Application for a non-material amendment following a grant of planning permission.
Town and Country Planning Act 1990

EP/119/17/NMA

Application for a non-material amendment following the grant of EP/6/17/HH to reduce the height of the outbuildings & change roof tiles from Grey roof tiles to Redland Concrete Plain tiles Charcoal Grey.

Drawing Title:
Proposed Site Plan, Proposed Works to Existing
Garage and Proposed Garage

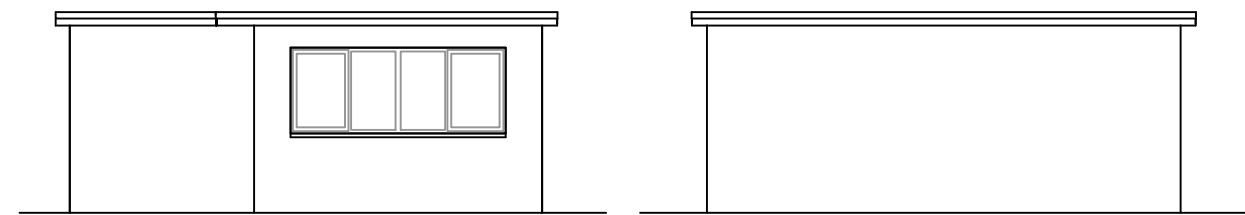
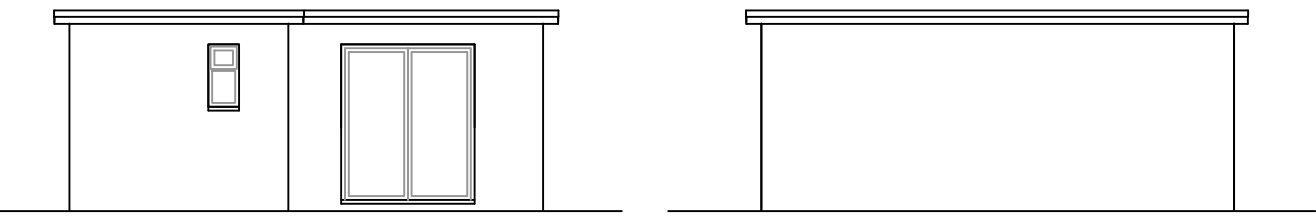
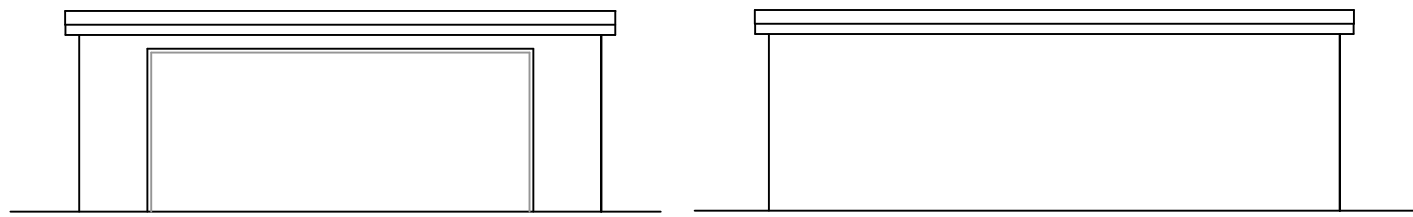
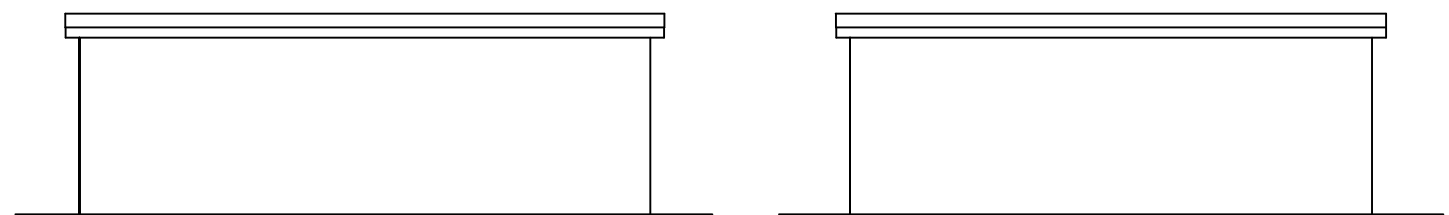
Removal of pitched roofs from proposed garage and existing garage and replacement with flat roofs.

To reduce the height of the outbuildings. Other neighbouring properties have outbuildings with flat roofs.
